Rezoning Transportation Analysis

Petition Number: 2019-168

Date	Description
12-18-2019	First Review
01-14-2020	Second Review (FO)
02-18-2020	Third (WB)

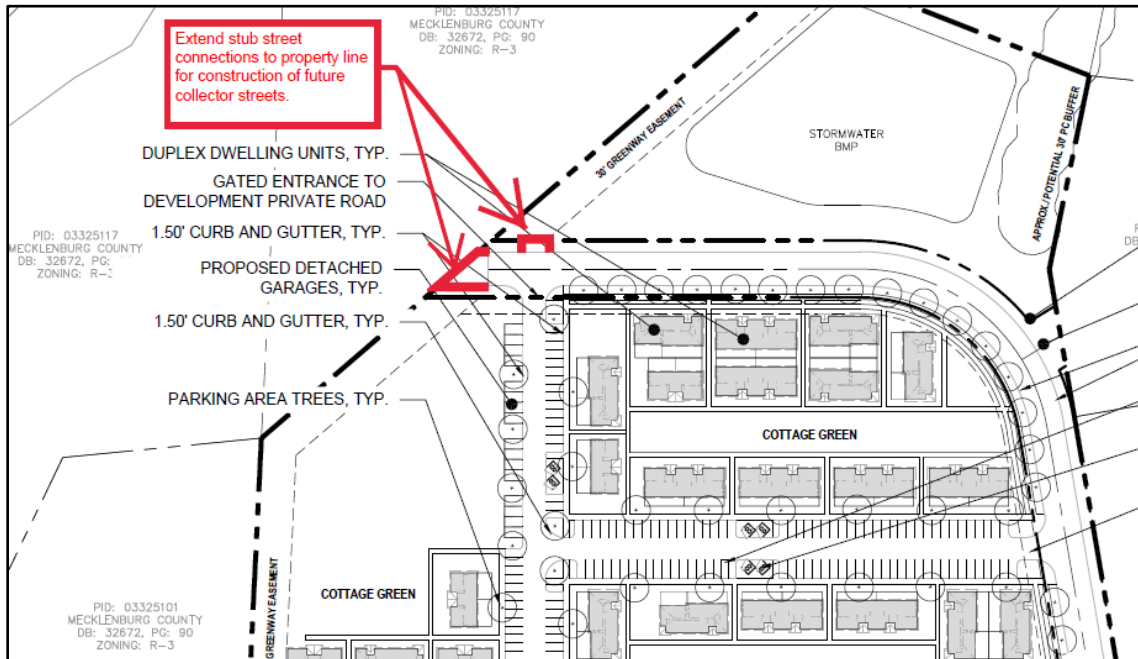
7. To comply with the council adopted Charlotte Walks and BIKE Policy, CDOT is requesting the petitioner construct a 12 foot multi use path along the Oakdale road. See multi use path shown above in green.

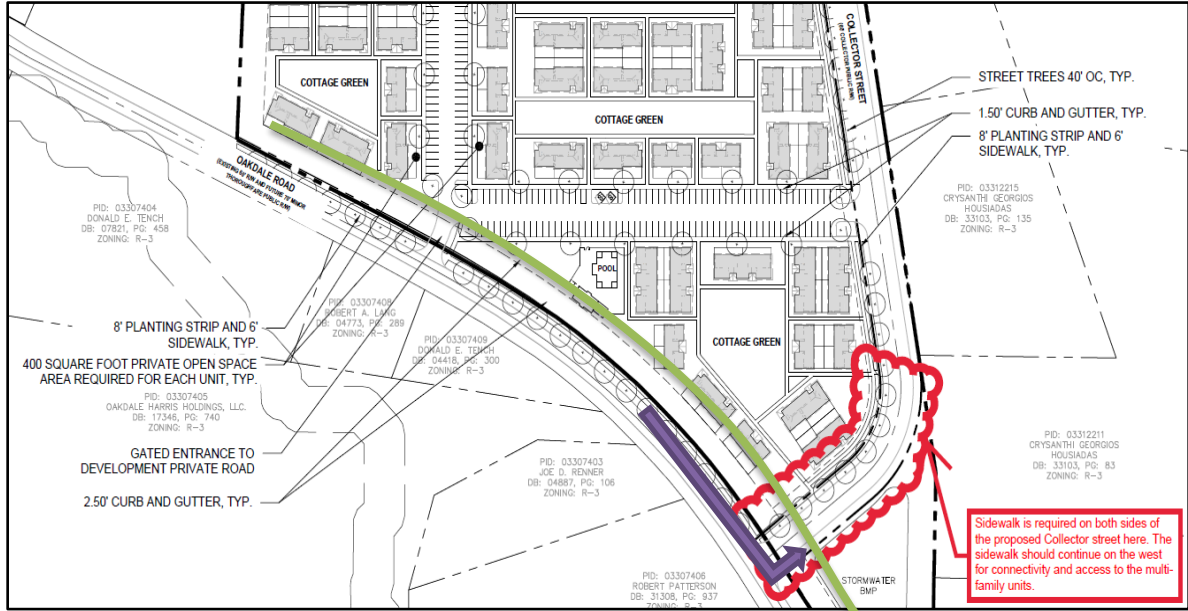
8. Per NCDOT, the petitioner should revise the site plan and conditional note(s) to include an eastbound left turn lane from Oakdale onto the proposed Collector street. See left turn lane shown above in purple.
